COUNTY COUNCIL'S RESPONSE TO CONSULTATION ON THE FOLLOWING DEVELOPMENT PROPOSAL

Application No: 18/00220/F-3

Proposal: Change of use of agricultural land to sport/recreation and community use.

Location: Land North of Milton Road, Adderbury, Oxfordshire.

Impermeable Roof	900,0 m ²	= 0,0900 ha
	Impermeable Hard standing	154,0 m ²	= 0,0154 ha
	Permeable Hardstanding	4,310,9 m ²	= 0,4311 ha
	Permeable Landscaping	30,894,1 m ²	= 3,1010 ha
Total Site Area		36,259,0 m ²	= 3,6259 ha

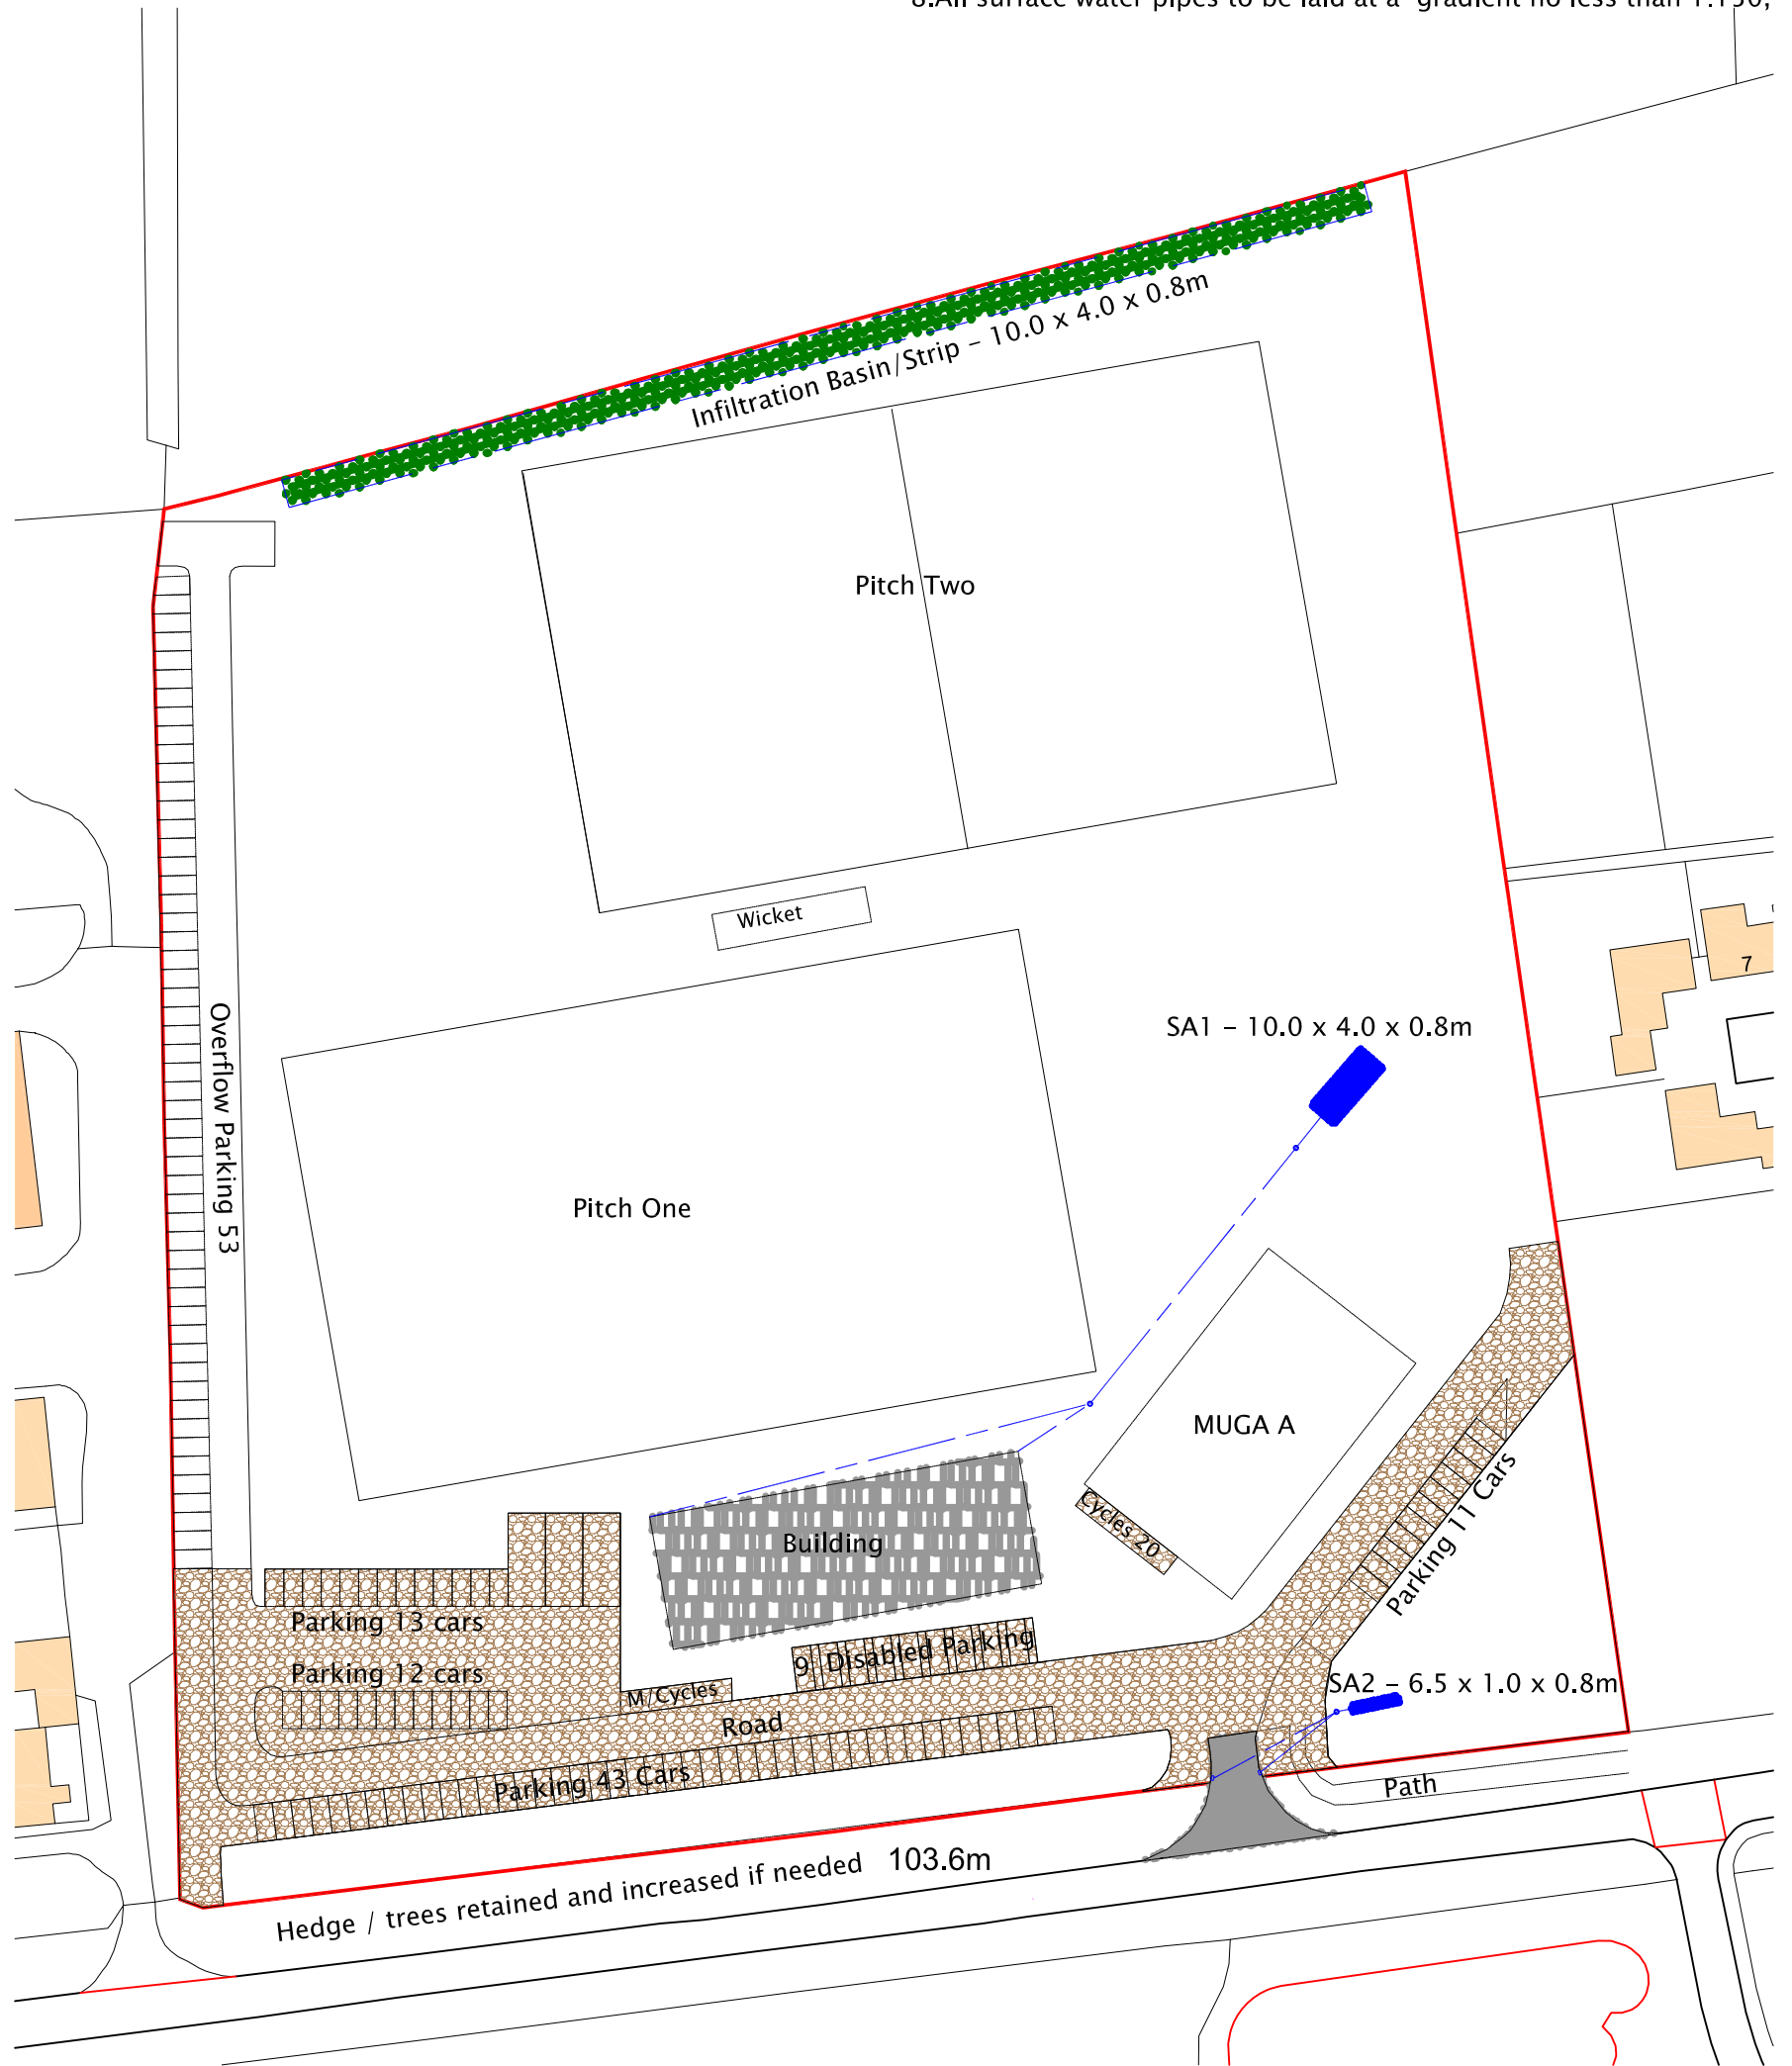
OCC (drainage) was unable to verify that the any design has been undertaken for the car parking areas. The applicant proposes to use a pervious paving; the design should ensure that sufficient subbase for storage of run off is provided such that no flooding occurs within the car park for the design event.

TEST 3

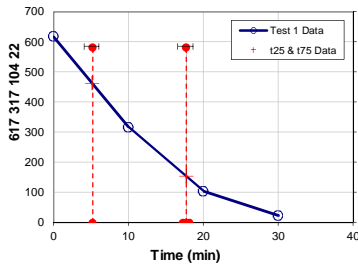
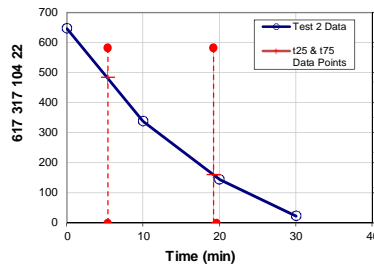
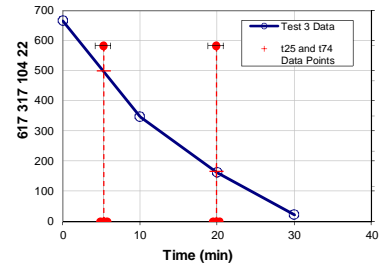
A single test pit has been taken at the site and OCC (drainage) would expect some additional test pits to confirm the potential and to inform the detailed design at specific SuDS locations. No indication has been provided as to the seasonal high ground water level at the site. A separation of one metre must be provided between the base of the infiltration device and the seasonal high ground water level.

Development shall not begin until a surface water drainage scheme for the site, based on sustainable drainage principles and an assessment of the hydrological and hydro-geological context of the development, has been submitted to and approved in writing by the local planning authority. The scheme shall subsequently be implemented in accordance with the approved details before the development is completed. The scheme shall also include:
